City of Albuquerque Stormwater Construction Site Inspection Report

ESC File No.	A11E017C	Project Name:	Tidal Wave Care Wash		
NPDES Id. No.		Location:	10601 Unser Blvd		
3/13/2023	Owner		Contractor		
Operator	TWAS Properties LLC				
Contact name & title	CO Joshua Skarsgard				
e-mail	Josh@retailsouthwest.com				
Contact Phone #	262-2323				
COA Inspector	Doug Hughes		Start/End Time:	9AM	
Construction Phase:	Building on lot 4 & both new and old disturbance on other lots				
Type of Inspection:	Regular	Storm Event	Post Storm Event >0.25"	311/Complaint	Follow Up
Weather at time of inspection?		Clear		Temperature: ~	50
Estimated date of last storm 0.25" or greater		12/4/2022

SILT FENCE

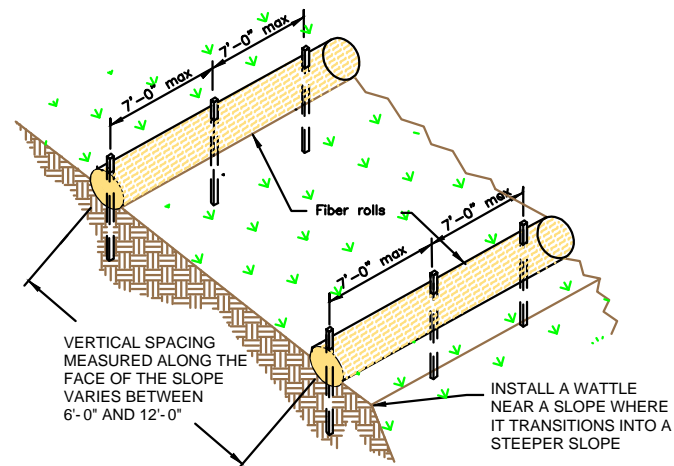
4	Stabilization was missing - You must continue permit coverage, self-inspections, SWPPP and BMP maintenance until the City determines that the Final Stabilization Criteria CGP2.2.14.c has been satisfied. Then you must remove the BMPs and send documentation of the Final Stabilization to the EPA with a Notice of Termination (NOT) per CGP 8.2 to end your coverage under the CGP. This step is independent of the Work Order. Please copy me with the documentation and the EPA's acceptance of the NOT at that time. In the meantime seed and Hydromulch are required per CGP 2.2.14.
5	BMPs missing - Silt fence is full of sediment on the east side. It is missing on the west side. Silt fence is required around the perimeter until the final stabilization criteria is satisfied.
